Ribble Valley Borough Council
Housing & Development Control

Application no: **3/2022/0826**

Address: **20 The Sands Whalley BB7 9TL**

Proposal: **To construct a first floor with pitched roof over, above a single storey extension to the property. Extending roof line 1.3 metres to the east with matching pitch and slate tile. Removal of an existing chimney. Dormer window to the rear of the property.**

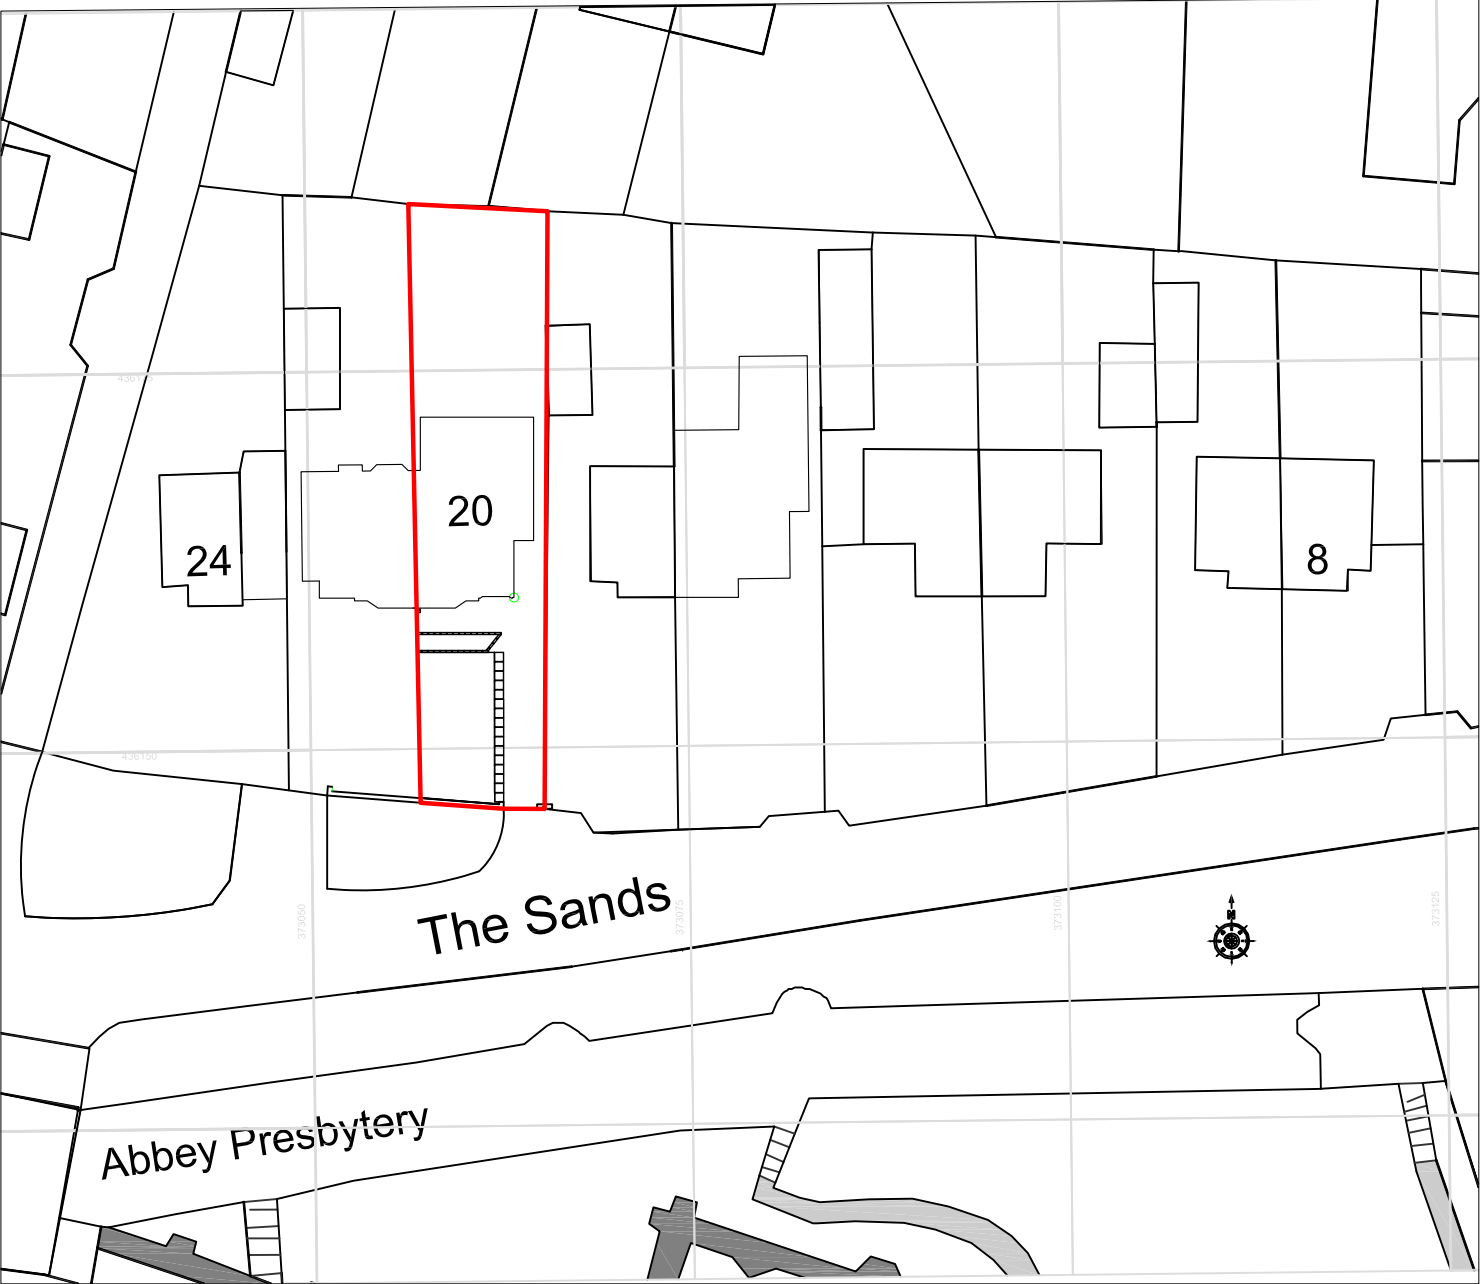
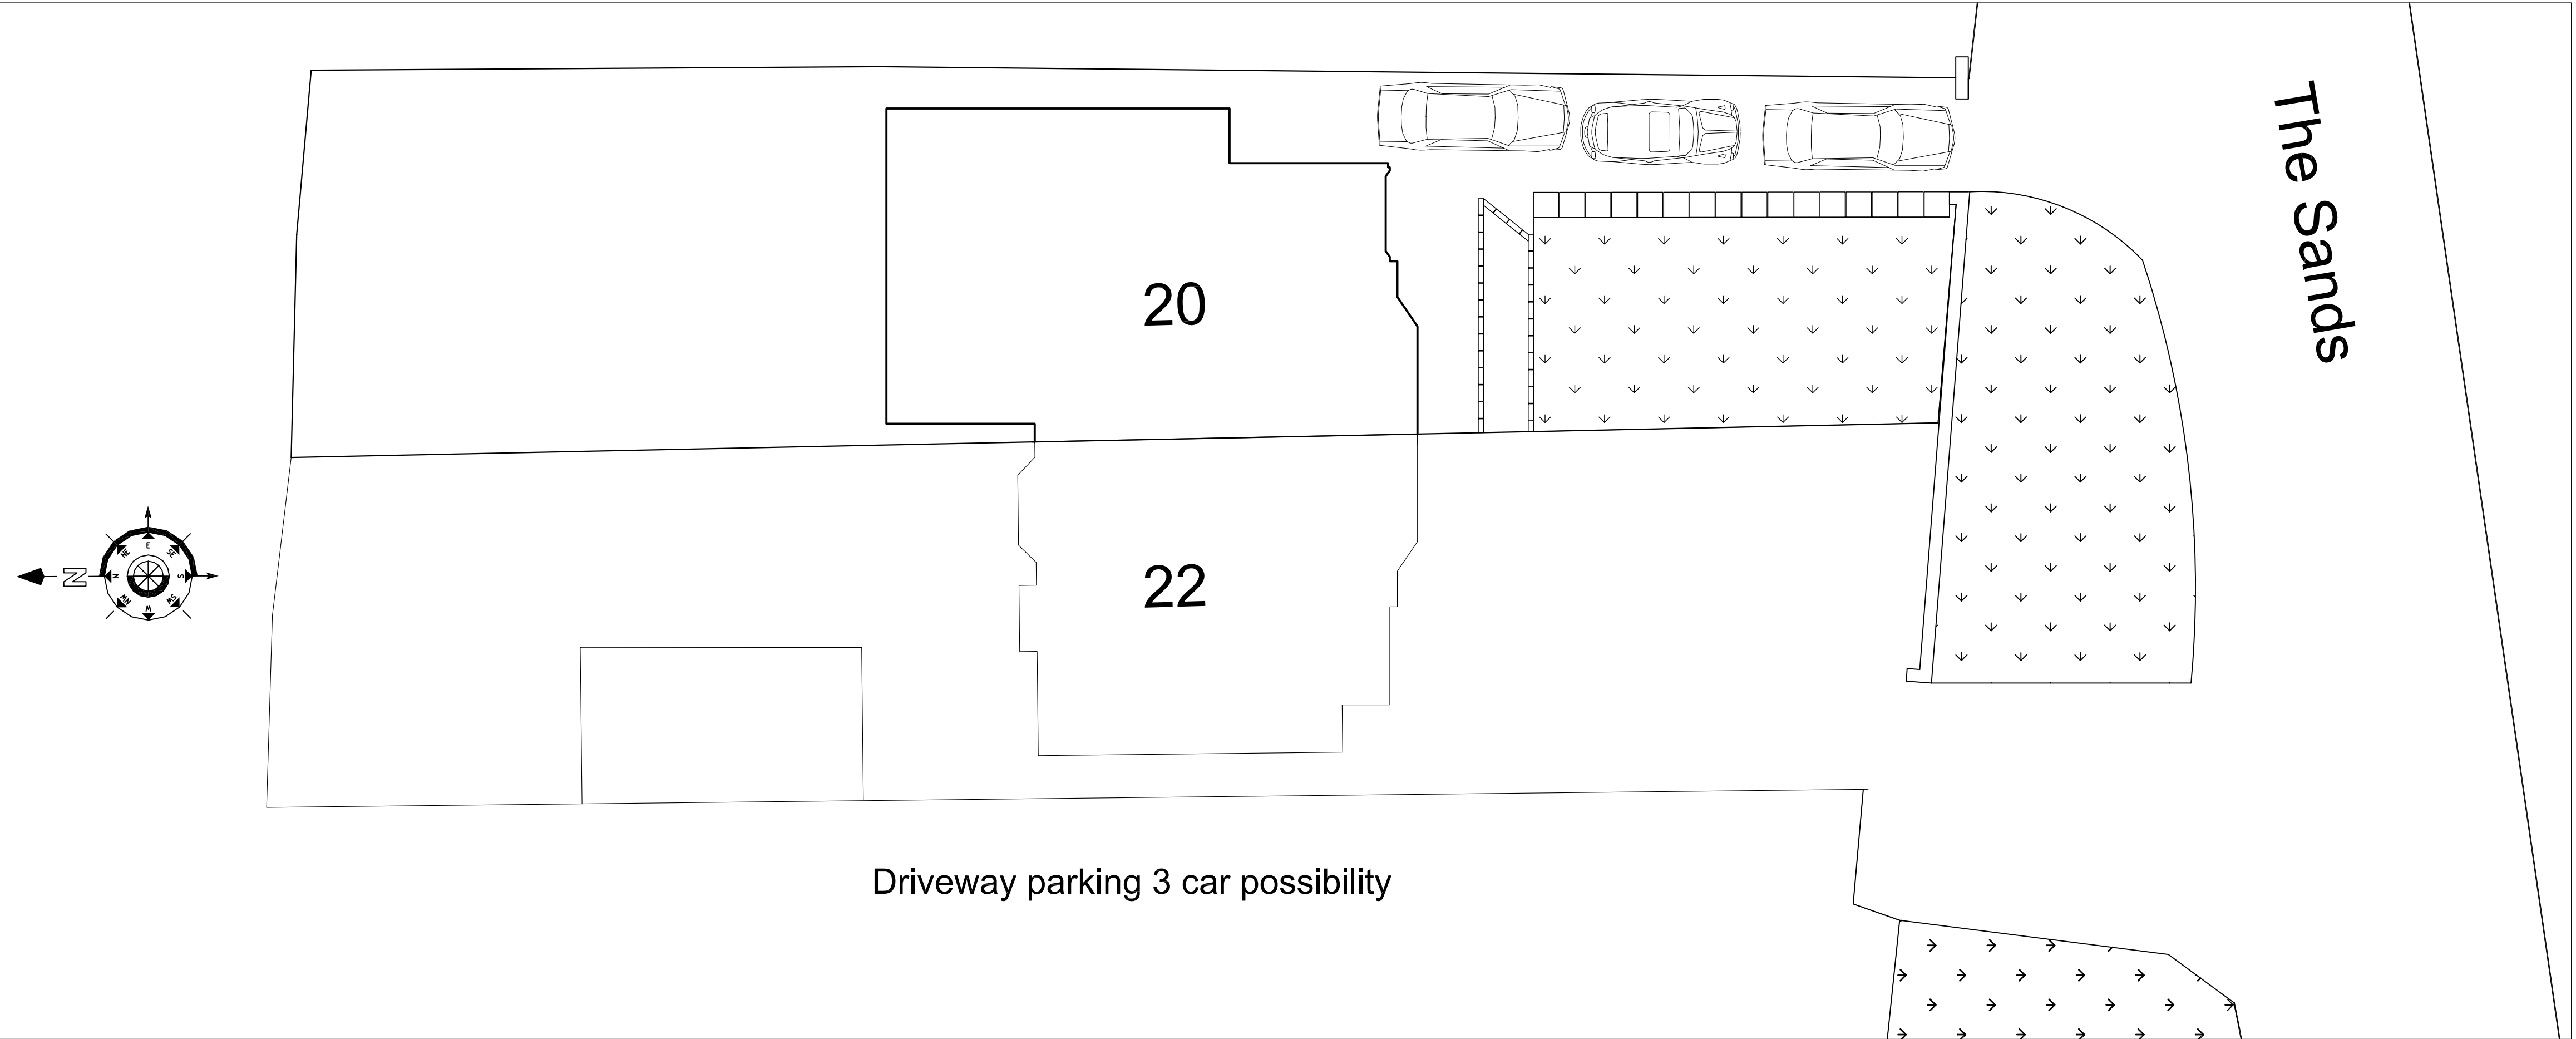
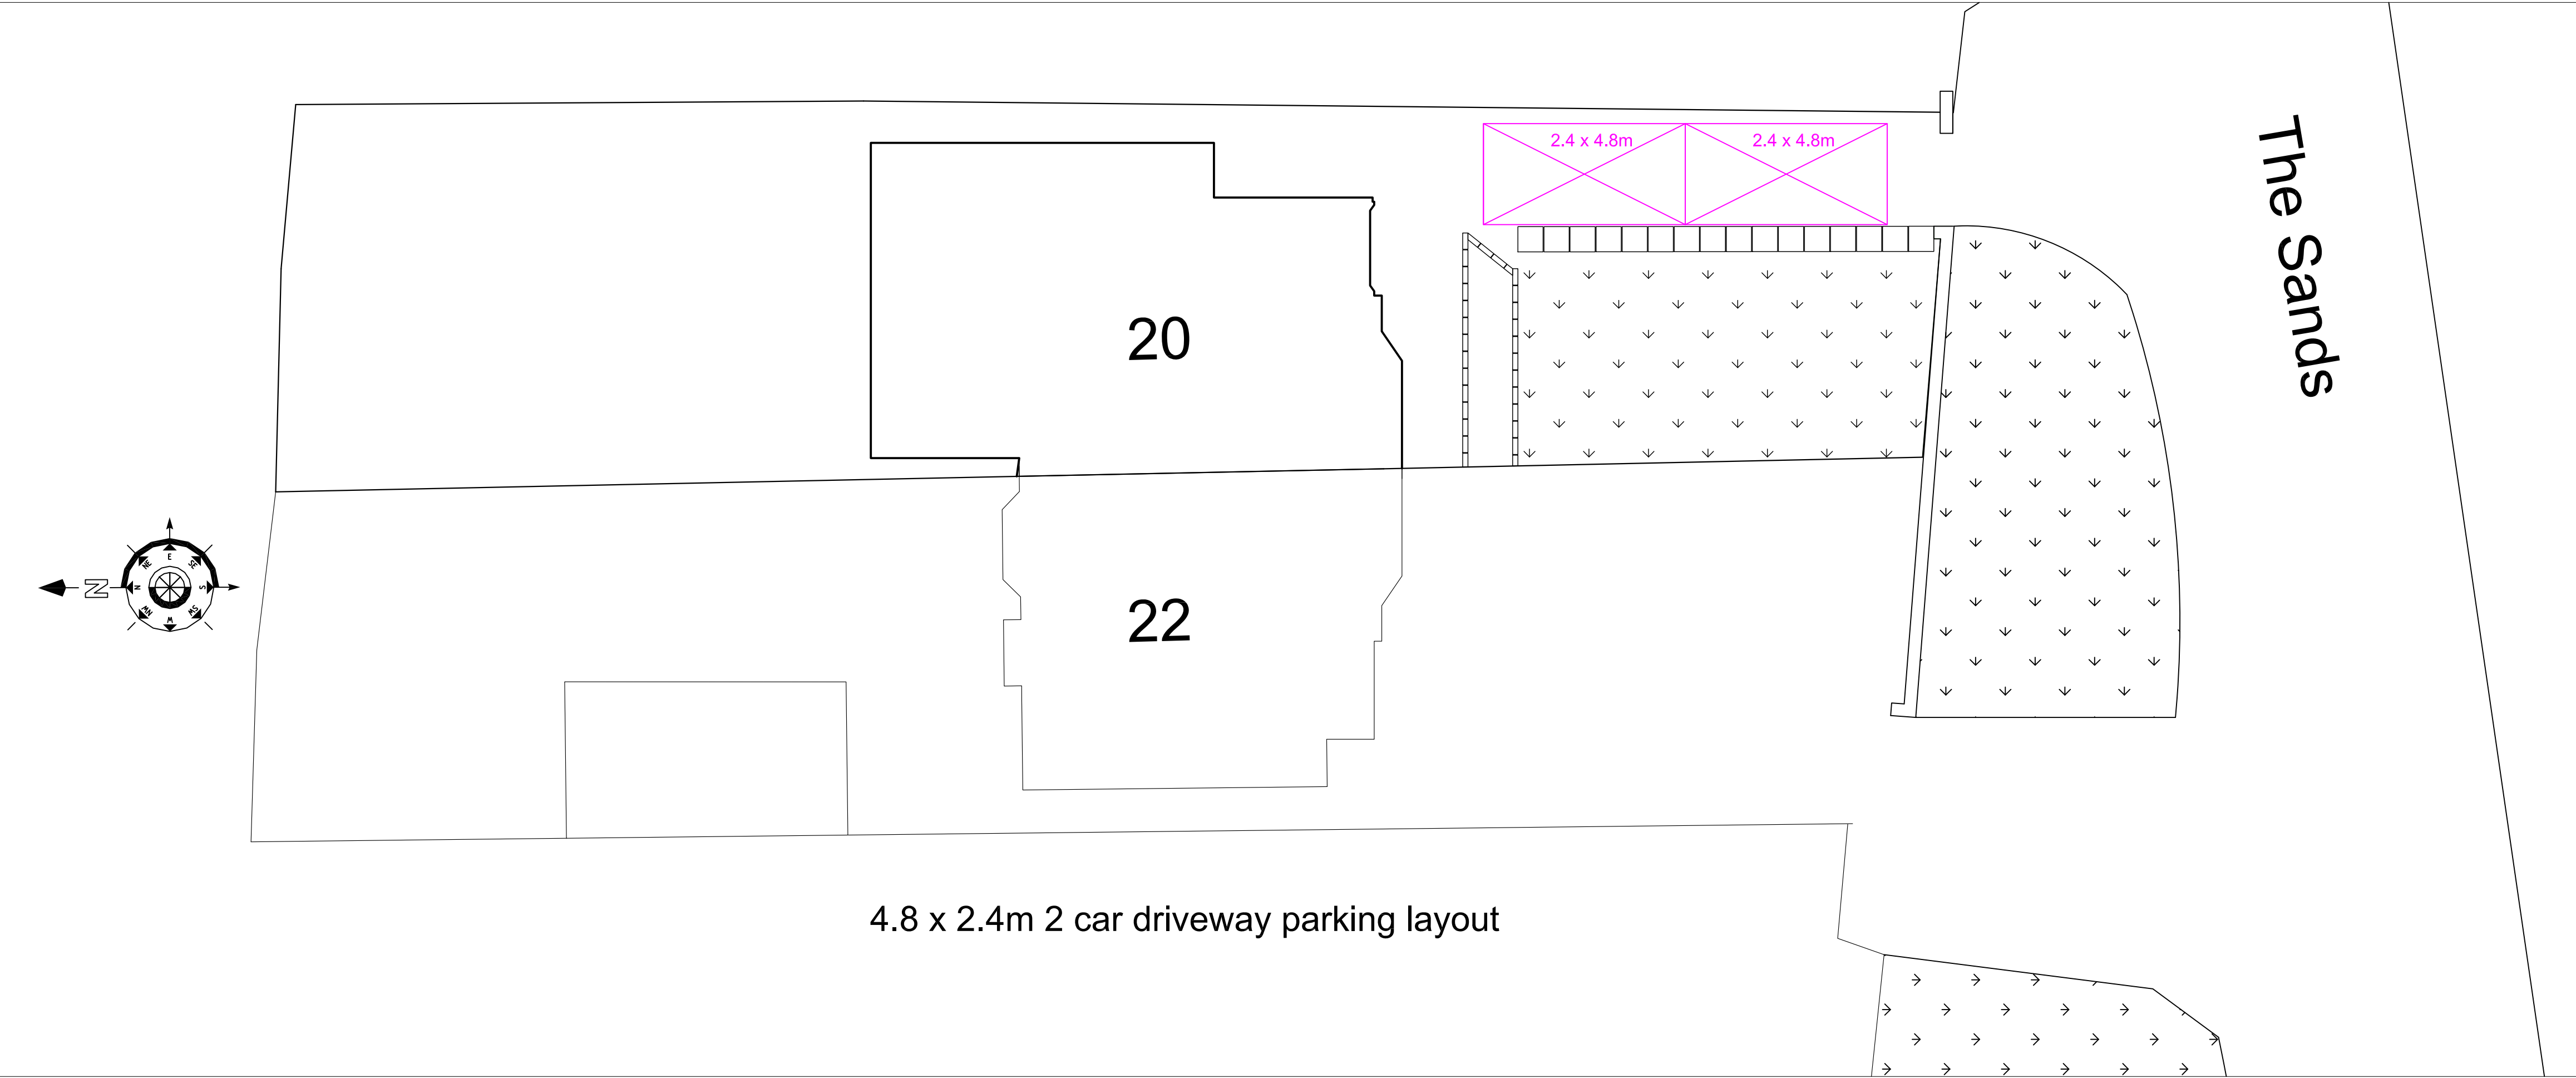
The LHA have reviewed the supporting documents and understands that the dwelling will become a 4-bed following the proposal. For the site to comply with the LHAs parking guidance as defined in the Joint Lancashire Structure Plan, the LHA require 3 car parking spaces to be provided on site.

Therefore, to ensure that the site can provide the minimum parking requirement, the LHA are requesting that a parking plan is submitted so that the LHA can fully assess the application.
